| Application Ref: | 3/2021/0377 |  <p>Ribble Valley Borough Council www.ribblevalley.gov.uk</p> | |
| DELEGATED ITEM FILE REPORT: | | Decision | Refusal |

| Development Description: | Proposed conversion of the existing integral garage and erection of a proposed double garage. |
| Site Address/Location: | 43 Hawthorne Place, Clitheroe, Lancashire. BB7 2HU |

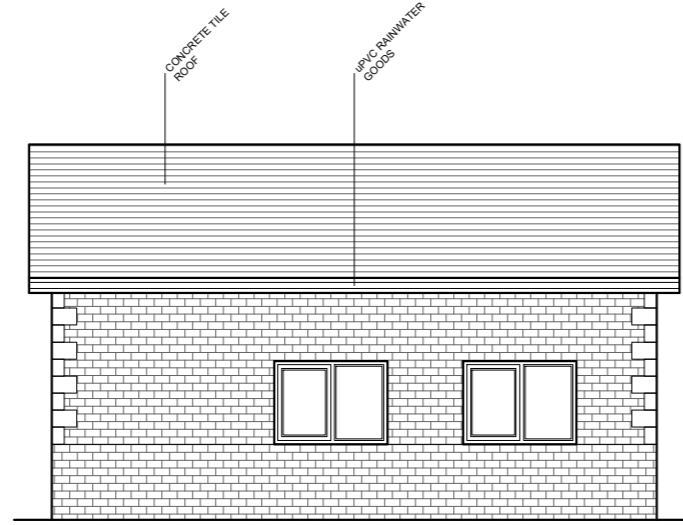
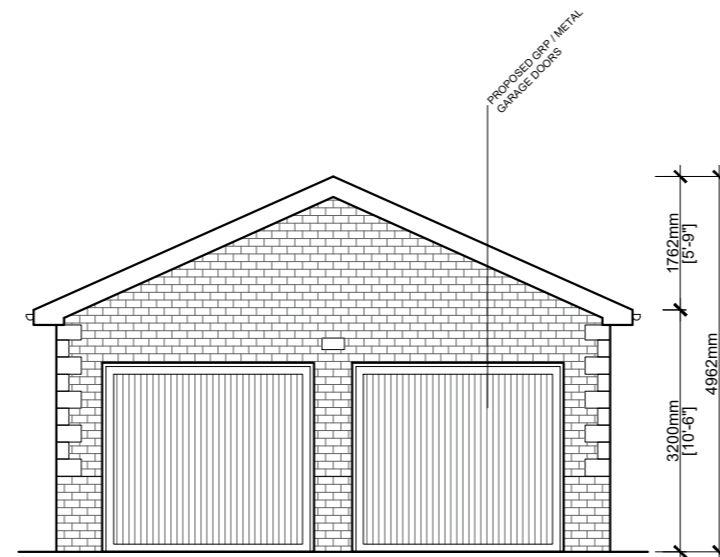
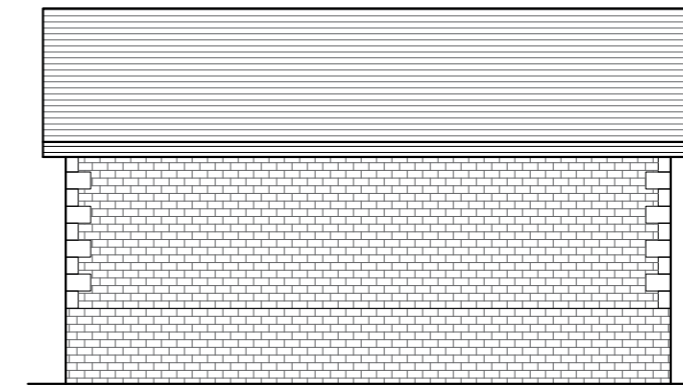
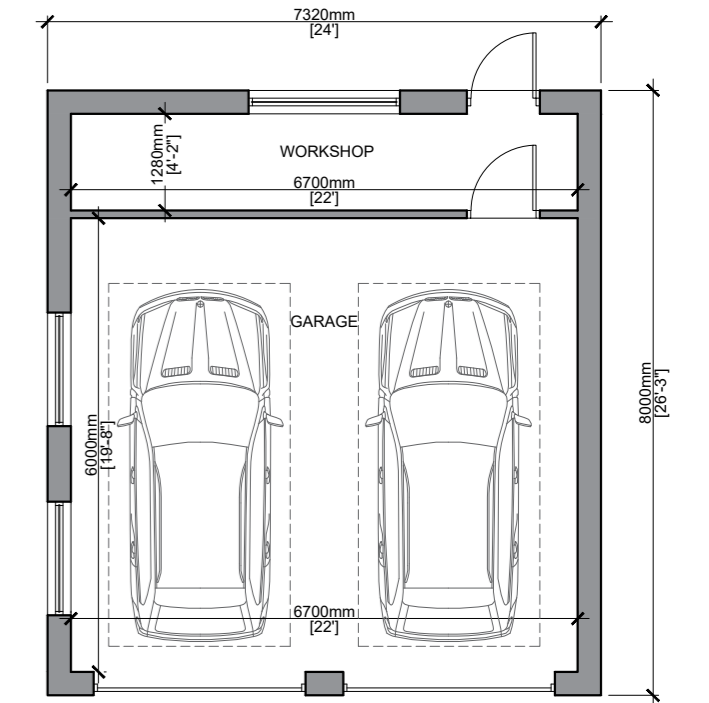
The proposed double garage includes windows on its rear and side elevations however given that the garage will not be used for residential purposes it is not anticipated that the proposed works will lead to any loss of privacy.

Standing at just over 16 feet tall and covering a ground floor area of over 58m², the proposed garage would be considerably larger than the other garages on Hawthorne Place and more reminiscent of a residential annex in terms of its size and appearance. Moreover, the garage would be sited within the front garden of the main property and as such the proposal would command a significant visual presence by virtue of its oversized height, footprint and high level of visibility within the public realm.

The proposal would also be visually prominent to the neighbouring residents of No. 41 Hawthorn Place and Ashdown in as much that the garage would project well above the height of the boundary fence with these neighbours of which it would be in close proximity to.

PROPOSED SITE PLAN SCALE 1:200

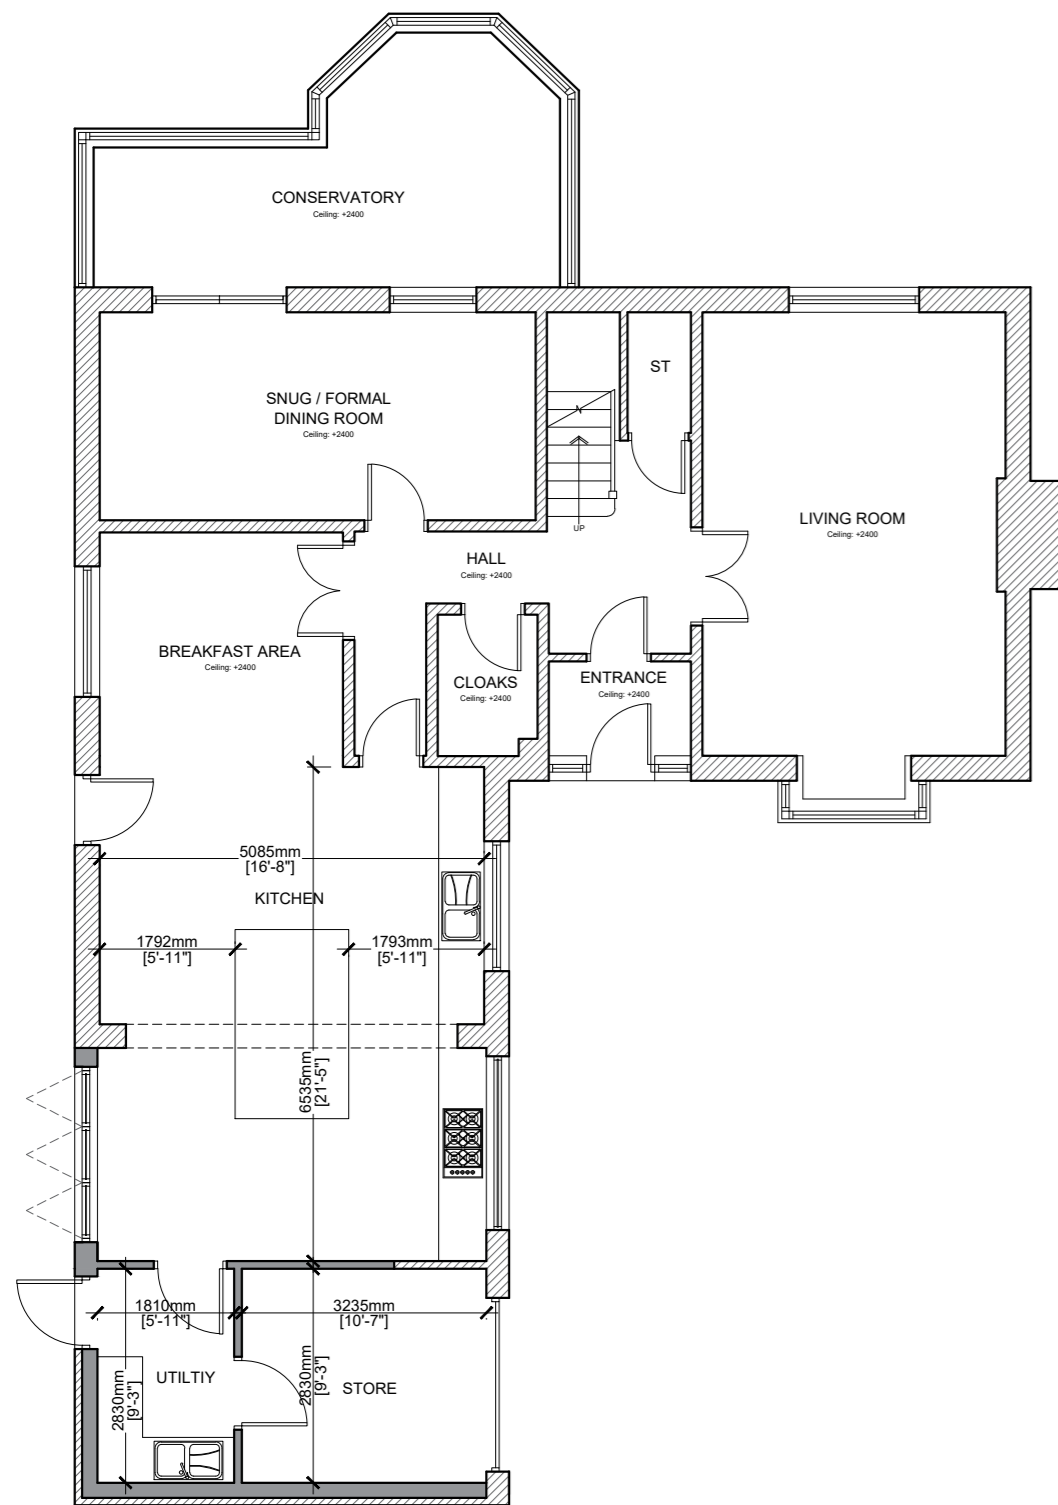
The proposed double garage be in close proximity to the conservatory of No. 41 Hawthorne Place which is situated on the rear elevation of this property approximately 5 metres away to the North-east. The garage would also be in close proximity to the rear garden of this property in as much that it will be sited just 1.1 metres away from the neighbouring boundary fence.

Accordingly, it is considered that the siting, height and proximity of the proposal to the neighbouring property of No. 41 Hawthorne Place would lead to a significant occurrence of overshadowing within the directly adjacent rear garden which in turn would result in an unacceptable loss of natural light provision for the residents of this property.

Furthermore, the garage would be sited 3 metres from the boundary fence with Ashdown, 2 metres from the side elevation of No. 43 Hawthorne Place and just 1.1 metres from the boundary fence with No. 41 Hawthorne Place which in turn would result in a particularly confined and cramped arrangement.

Policy DMG1 states that development must *'consider the density, layout and relationship between buildings, which is of major importance'* however in light of the above observations it is considered that the proposal categorically fails to give due consideration to the above policy through attempting to introduce a form of development that would be largely unsympathetic to the existing spatial arrangement between properties on Hawthorne Place.
